Project 71235.01
21 Feb 2011
TJW:III

**Placement of Scour Protection Blanket over Soft Sediments
Inner West Marina, Breakfast Point, Sydney**

Further to your enquiry regarding the geotechnical issues associated with the proposed scour protection blanket (SPB) at the Inner West Marina here are my comments on the item numbers in the David Crane & Ass report and other document that you specifically requested:

BED TREATMENT

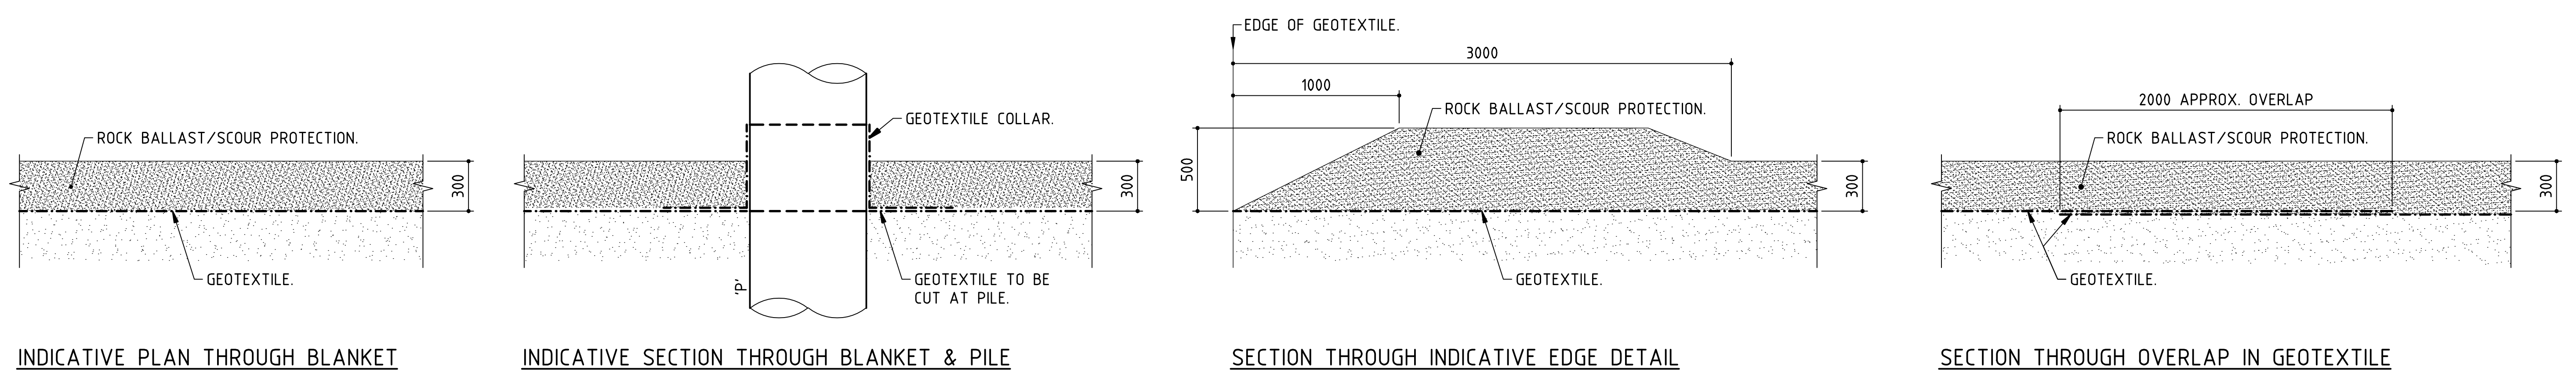
9. The proponent concedes (VOL 6 pg 35) the marina development potentially disturbs the contaminated sediments. The report considers this disturbance during constructions, post construction and marina operation. To mitigate the disturbance of the contaminated bed sediments it is proposed to use a geotextile and rock protection blanket. It is stated (VOL 6 pg 36) that the "upper 100 mm of very soft sediment would probably be disturbed" when the geotextile and rock blanket are laid. This estimate of 100mm is based on a report by Douglas Partners (DP). The DP report provides no basis or justification for this "estimate". The "estimate" appears to be based on the fact that the soil behaves as a highly viscous fluid. It is unclear why this would apply to a depth of 100mm only. The bioturbation of organisms will likely penetrate several hundred millimeters below the surface. Vol 3 pg 5, shows that bivalve shells are present below 1.5 metres. As consequence, it could equally be estimated that the disturbance depth will significantly exceed the 100mm. A value of 400 to 500mm is considered more likely.

10. The construction and long term performance of the blanket has clear geotechnical implications, yet no geotechnical in-situ or other factual data has been collected. The lack of factual geotechnical data at this stage is considered to be a serious omission. Because of its underconsolidated nature, the very soft contaminated sediments will experience significant displacement through localized bearing capacity failure when the rocks are placed. This will occur when the armour store is placed on the geotextile and it sinks and in the process move some of the material laterally after which the displaced sediment moves up vertically a short distance from the rock placed. This will result in a wavy surface not a horizontal surface as depicted on Diagram 3 of Figure 8 (Vol 6). The effect is illustrated on Figure A. This waviness could be up to several hundred millimeters USEPA (1998) recommends increasing the blanket thickness by 50% to overcome the uncertainties with this type of construction when carried out under water. Therefore, to obtain an effective rock armour cover of 300mm, a minimum of 450 mm would be required. The proponent has failed to demonstrate that the proposal will not result in significant uncontrolled disturbance of the sediment during rock placement.

11. The proponent may argue that geotextiles are used as a reinforcing member in civil engineering projects to overcome the effects of low strength soils. This is correct, however, when using a geotextile for reinforcing purposes a woven fabric is usually used, not a non woven fabric as proposed at Kendall Bay. Woven fabrics have distinct fibres that act like the steel in reinforcing mesh. Woven fabrics are usually a very poor separator that is why the proponent is using a needle punched spun bound geotextile (Elcomax 1200 R). This type of geotextile has fibres that run in random directions and need to stretch a significant amount to take up load. Therefore they are not suitable to be used as a reinforcing element.

23. The matter of bathymetry is considered to be important for an ISC (USEPA 2005). It is stated that the flatter the bottom slope the better. This is to reduce the spreading of the capping material during placement. It is also stated that it is difficult to estimate the effects of slope alone, since bottom roughness plays an equally important role in the mechanics of the spreading process. Given the normally and underconsolidated nature of the contaminated sediments, the bottom slope in Kendall Bay is considered to be a very important factor in the selection of the correct method of remediation. Palermo et al (2000) offers some insight into the issue of bottom slope. In this publication the issue of level bottom capping (LBC) is discussed with reference to dredged material capping. This is where dredged contaminated sediments require capping to mitigate the potential for toxicity or bioaccumulation in benthic organisms. These dredged sediments would be very soft similar to those in Kendall Bay. The following is from the document "... LBC projects ...have been executed at sites with slopes up to 1 to 60 ..." "Placement of material on steep bottom slopes (steeper than 1v on 100h) should generally be avoided for a capping project... because of the potential for a slope adjustment ...". Using these criteria it can be concluded that the bottom slope at Kendall Bay is far too steep for the proposed ISC.

Tests can be carried out to determine the depth and extent of disturbance and refine placement techniques so that no more than 100 mm is disturbed. It is feasible that refinement of both design and construction procedures could result in almost no disturbance to the sediments.

I agree in part, but the extent that the sediment surface is displaced will depend on the strength of the sediments around and the shear forces in the sediments that result from the placement of rock. Placement can be very closely managed using for example a controlled feedpipe or diffuser. Consideration should also be given to initially placing a layer of sand over the geotextile before rock fill. Full scale trials would enable a contractor to fine tune his equipment and procedures.

The primary purpose of the geotextile at Breakfast Point is to separate the contaminated sediment from the clean fill. Although a geotextile was not eventually used in the seagrass habitat area at the Sydney Airport Parallel Runway project due to reasons given previously the recommendation made at the time is detailed below:

If capping is still to be carried out, we suggest placement of a stiff geofabric or grid to form a separation layer between the capping and underlying clays prior to carefully controlled placement of sand. A coarse weave, non buoyant cane or plastic mat or webbing may be suitable in providing lateral stiffness and strength combined with physical separation between the silts and sand capping layer. It would be prudent to monitor the placement and possibly stage the capping to avoid large scale lateral displacements.

This may be true but requires strength values for the clays and accurate modelling of sub-seabed stratification to analyse reliably. Figure 1 indicates shear strengths required for stability of a sand batter of 1V:5H. The batter of the blanket has a greater impact on the stability of the edge slope of the capping than the bottom slope provided the bottom slope is less than 1V:15H.

The bed of Kendal Bay slopes at shallow angles of 1:25 (V:H) or flatter. Placement of the rock capping layer will need to be controlled so uncontrollable spreading does not occur. Edge batter slope will depend on sediment shear strength with the stable edge batter likely to be closer to 1V:5H than 1V:1.5H.

INDICATIVE PLAN THROUGH BLANKET

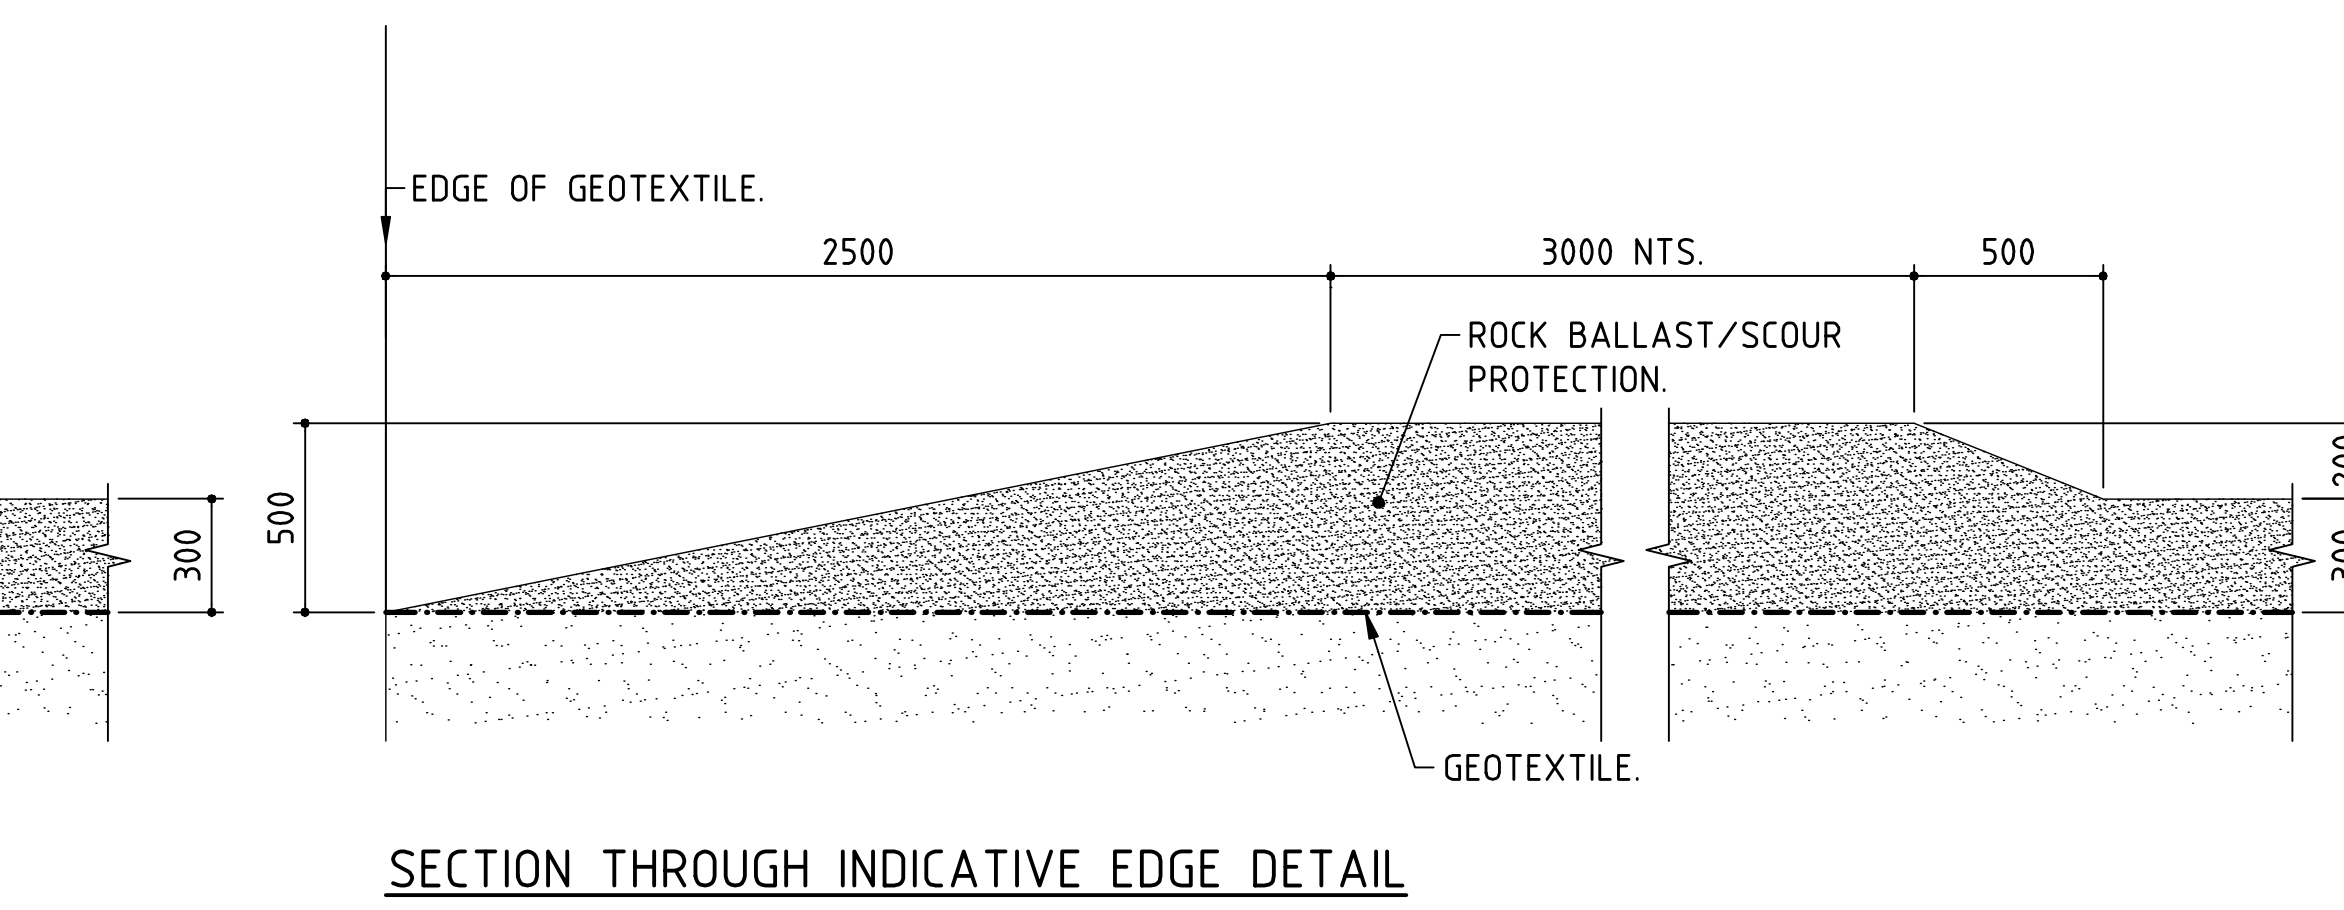
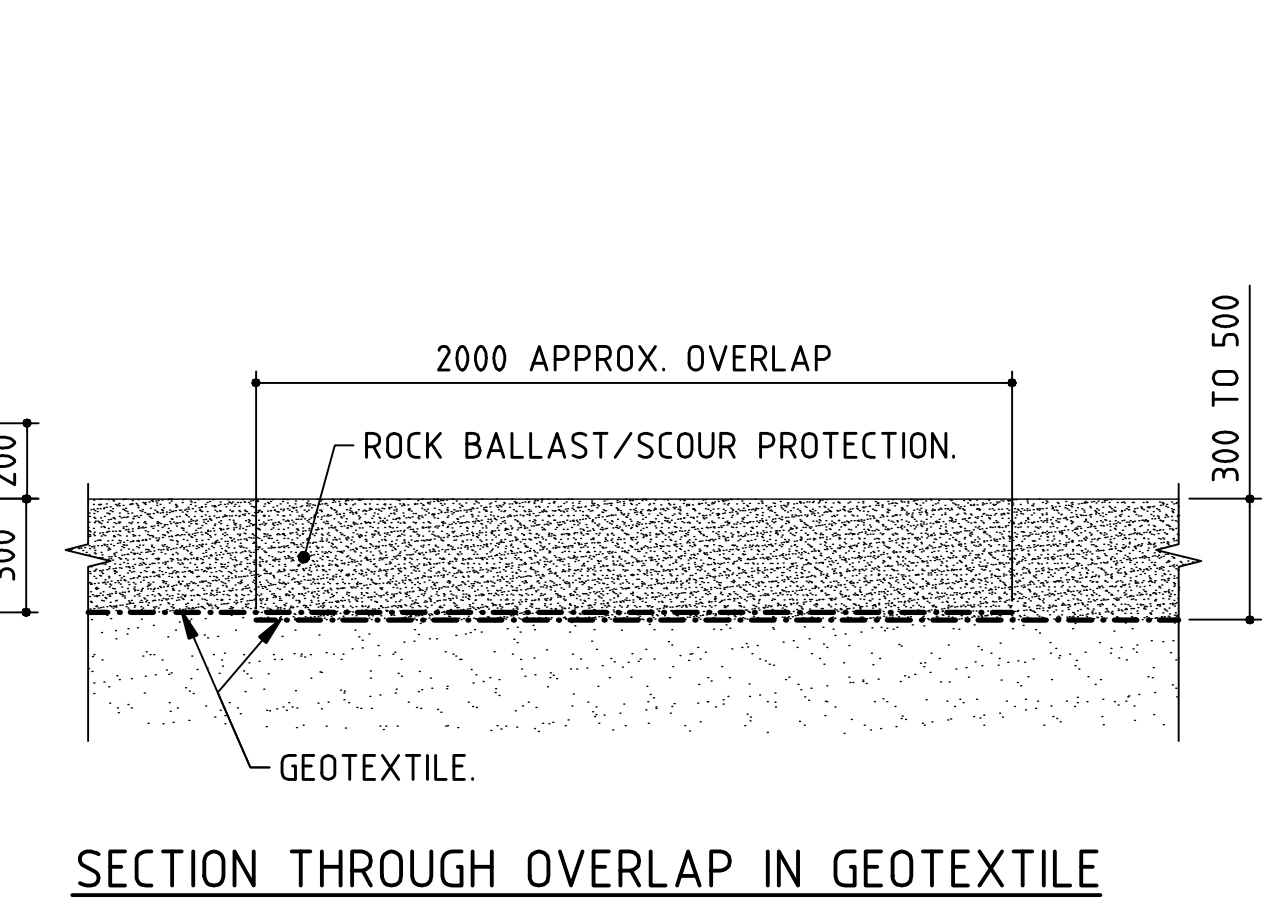
2.4: Page 43 	"...the basalt, rock would be placed on the geotextile using the excavator with GPS controlled bucket."	This methodology has the risk that along the edges of the Ecomax 1200R (i.e. with unprotected sediment adjacent) it is likely that there will be disturbance of the sediment such as by overspill or a local bearing capacity failure due to the load concentration. This is possible as the sediments are described in reports as "very soft" etc; however there is the omission of no objective Geotechnical insitu strength testing. If a bucket full of basalt were dumped on the edge of the mat it is highly likely a local bearing capacity failure would occur in the unprotected sediment contaminants thrust into the water and migrate away.	FDR, FMR CDGR (1.7)
---	--	--	--------------------------------

This is correct in the absence of insitu testing there is a risk of bearing capacity failure particularly at the edges. An edge batter of 1V:5H or less is suggested as discussed above.
